Commitment Letter

Project Name: Rolling Hills Ranch at Meridian Ranch, Filing 1-3

Electric Provider Commitment Letter _V1.pdf Markup Summary

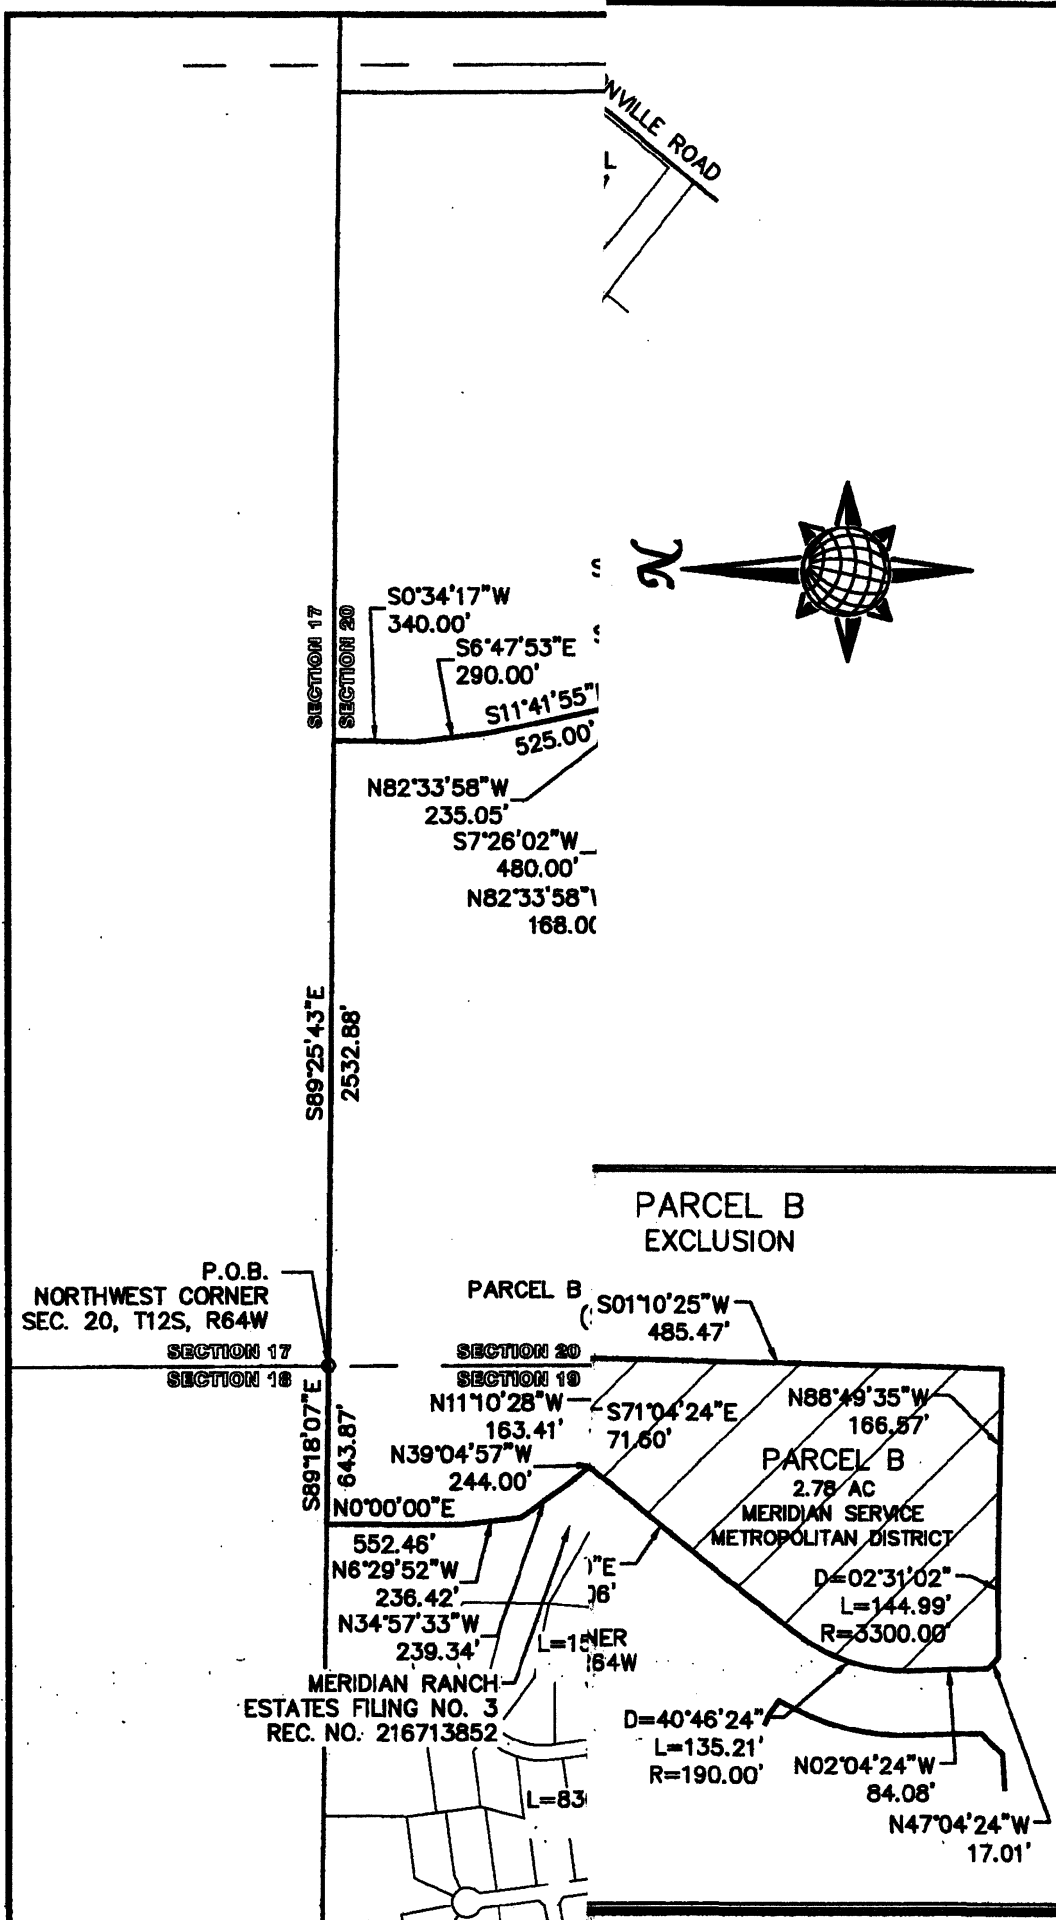
Revise Plat Document to show dedication of a minimum 20-foot easement for utilities on exterior of subdivision or identify a Tract for the proposed utility use that meets the stated requirement.

Revise Plat Document to show dedication of a minimum 20-foot easement for utilities on exterior of subdivision or identify a Tract for the proposed utility use that meets the stated requirement.
